Gosford City Council

**RE: Environmental Assessment for Central Coast Cancer Centre, Gosford Hospital.
(MP10-0173)**

**DRAFT CONDITIONS OF CONSENT Exhibition Major Project Application MP10 0173
Regional Cancer Centre Holden street Gosford**

DRG No:
DoP 05
REVISION:
02

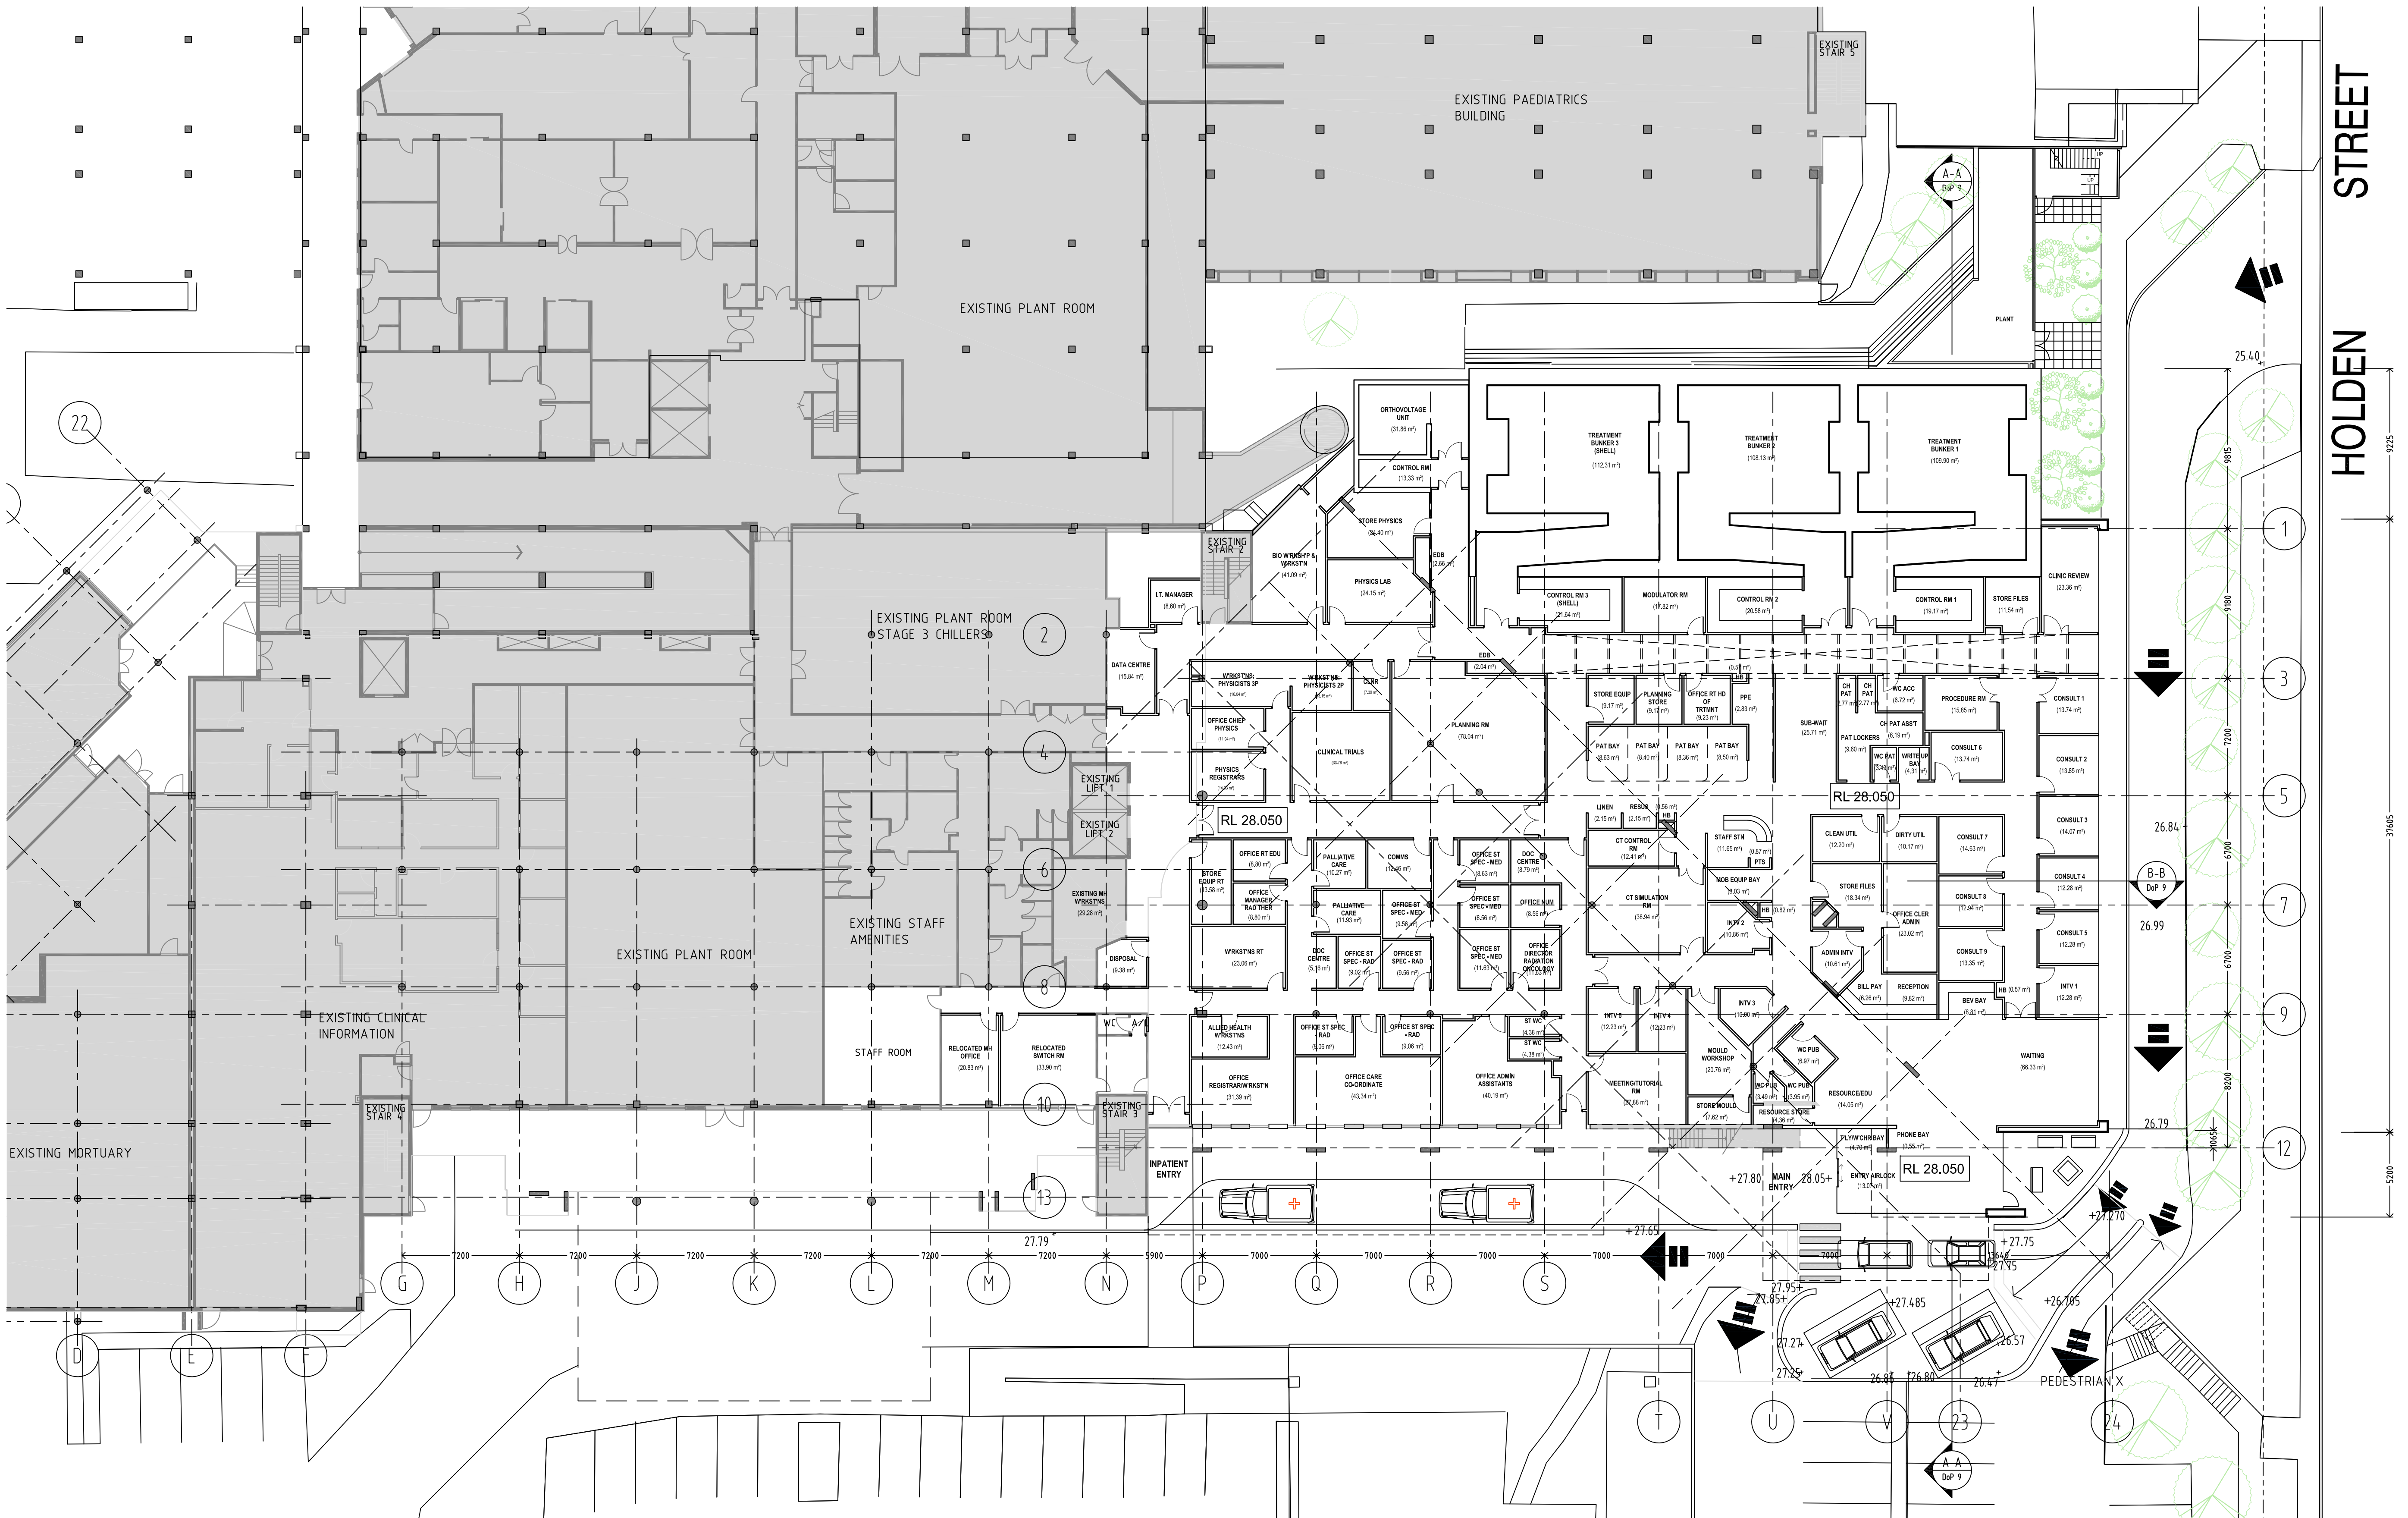
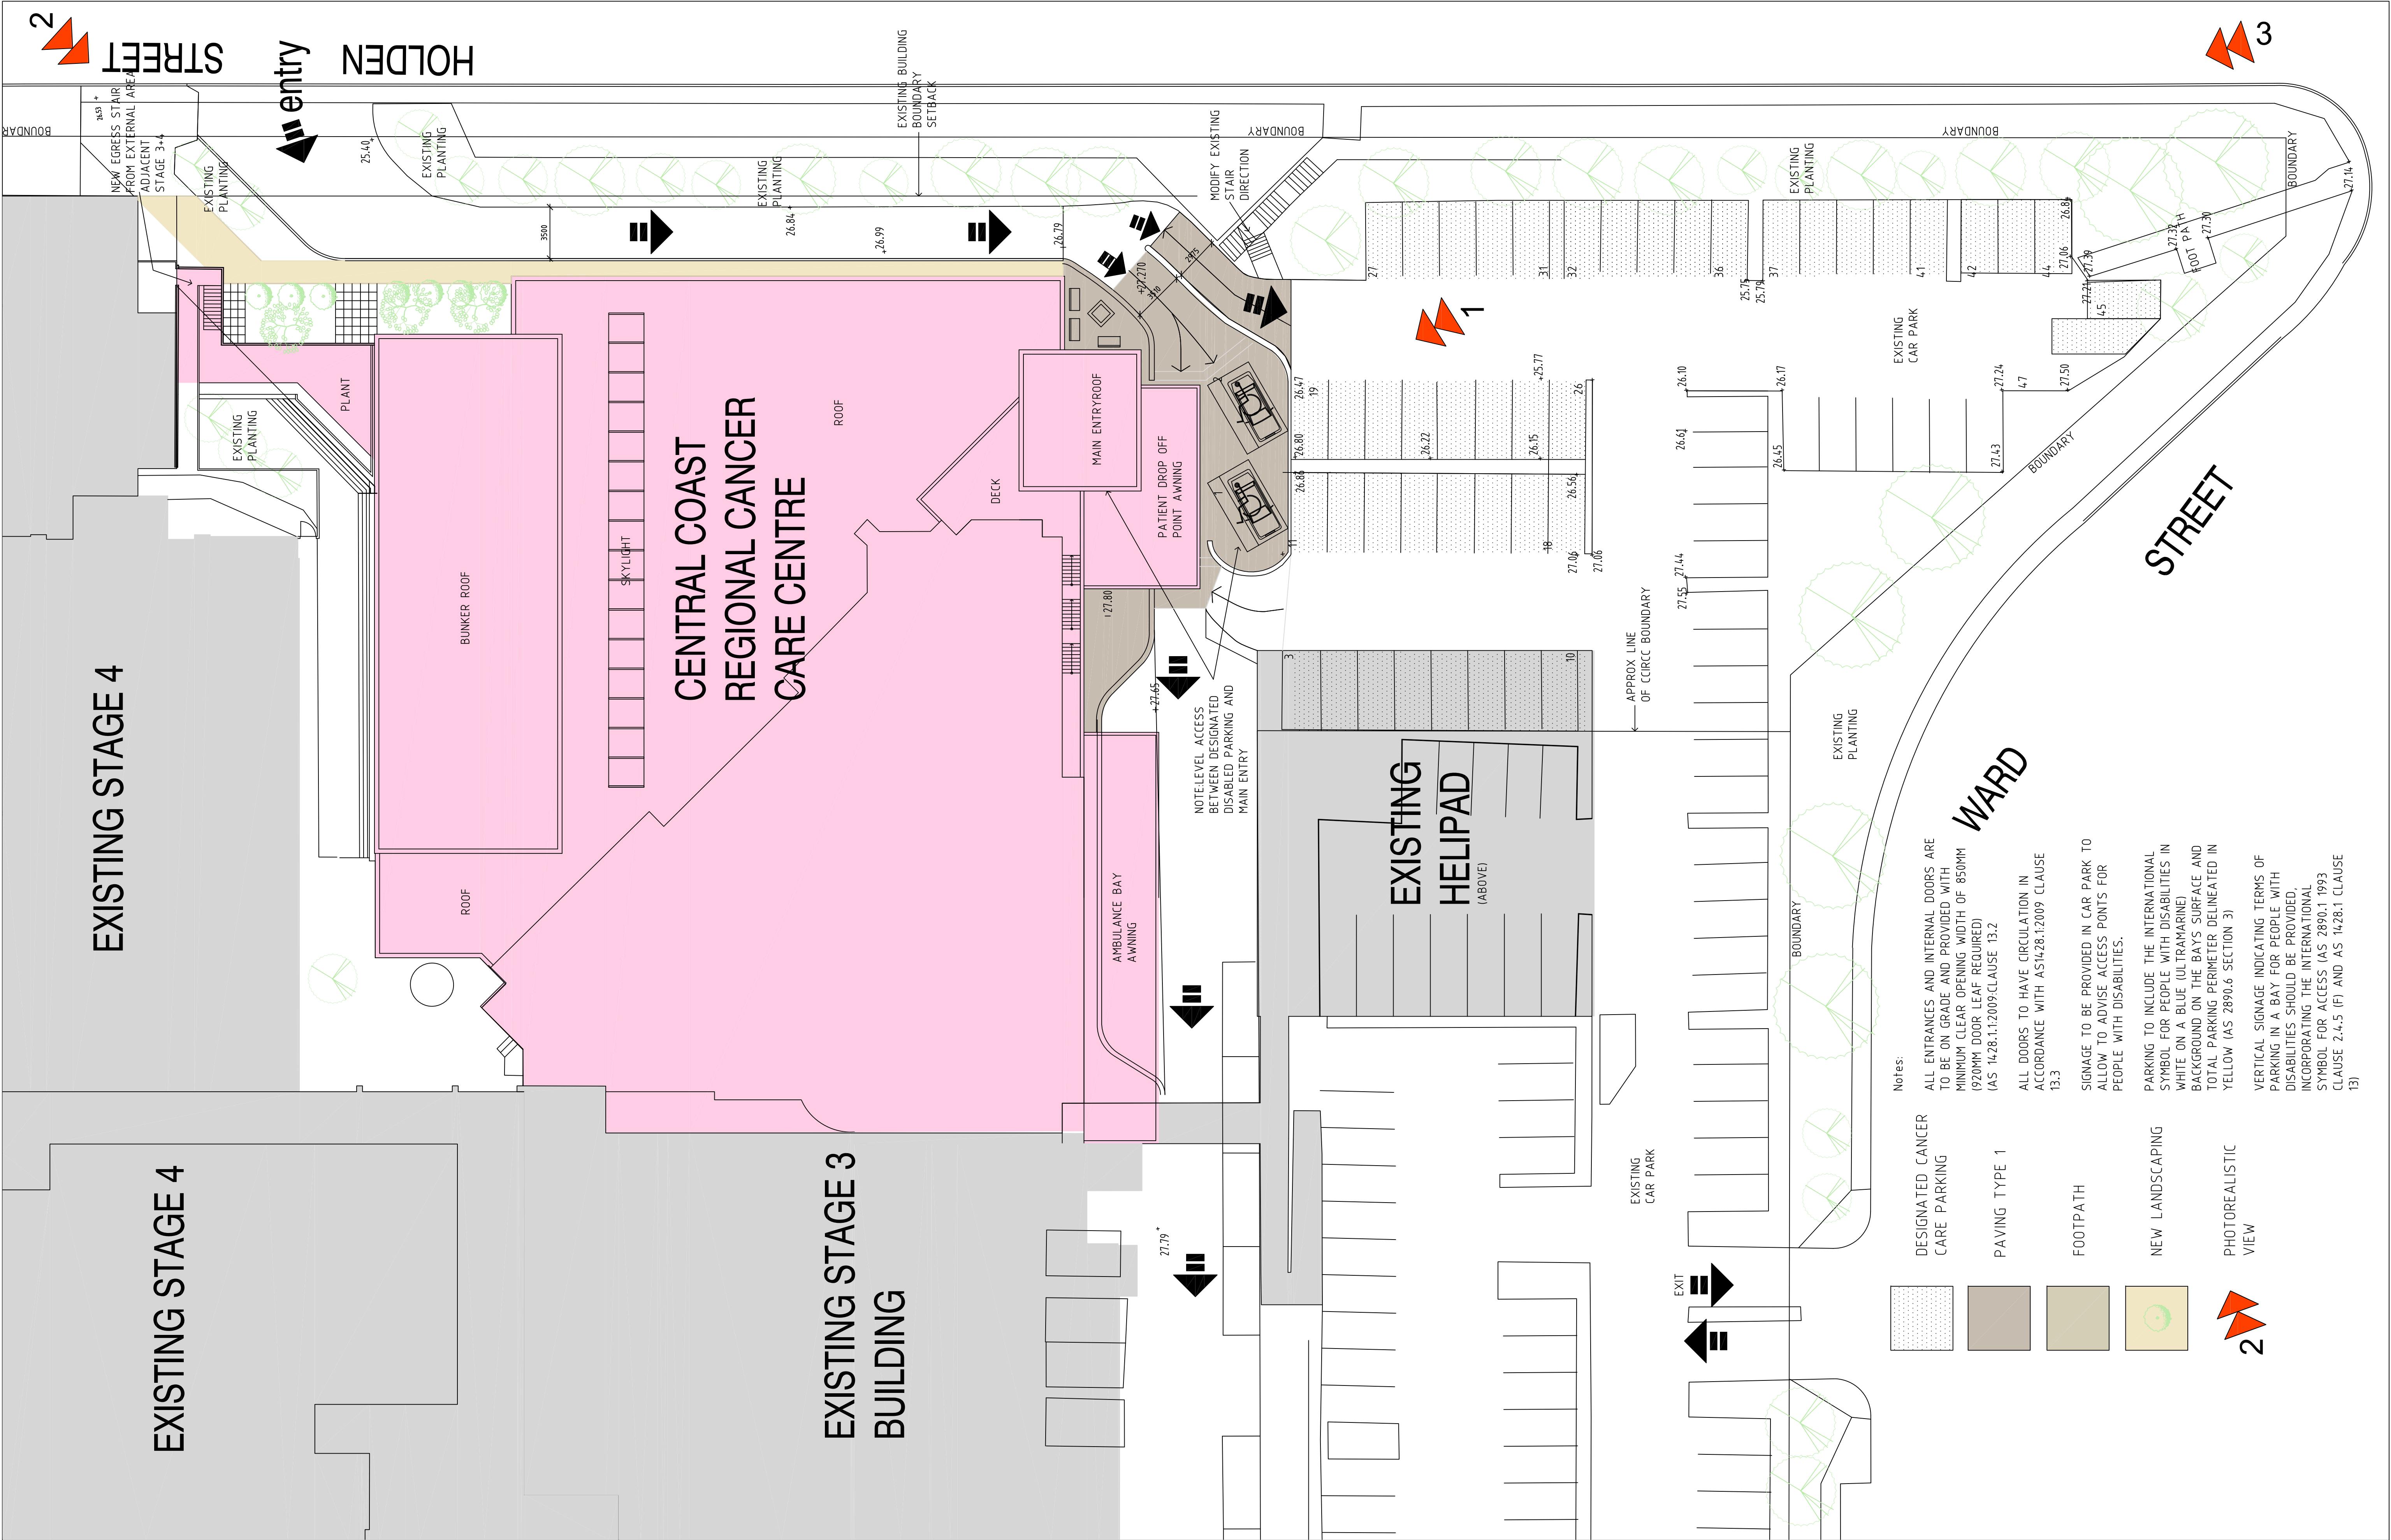
- 3) An additional exit driveway should be provided in Ward Street at the western side to compensate for the deletion of the exit driveway to Holden Street.

- 8) The separated two level vehicle access also conflicts with the pedestrian entry from Holden Street which requires pedestrians to take a circuitous walk around the wall and through the car park rather than a clear and pleasant route to the entry.
- 9) The parking and vehicle access appears confusing with numerous entries and exits. A comprehensive traffic and parking plan should be prepared. This should be addressed in the Plan of Management for the Hospital site which is currently being prepared.

- a. Half width road shoulder across the full frontage of the site at Lot 2 DP382500 No 96 Ward St.
- b. Footway formation graded at +2% from the top of kerb to the property boundary, across the full frontage of the site at No 96 Ward Street.
- c. 1.2m wide reinforced (SL72 steel fabric, 100mm thick) concrete footpath in an approved location across the full frontage of the site at No 96 Ward Street.
- d. Heavy-duty vehicle crossing that has a width of 6m and constructed with 200mm thick concrete reinforced with 1 layer of SL72 steel fabric top and bottom.
- e. The piping of stormwater from within the site to Council's drainage system.
- f. Alterations to the driveway in Holden Street.
- g. An additional exit driveway at the western end of Ward Street from the Hospital car parking area.
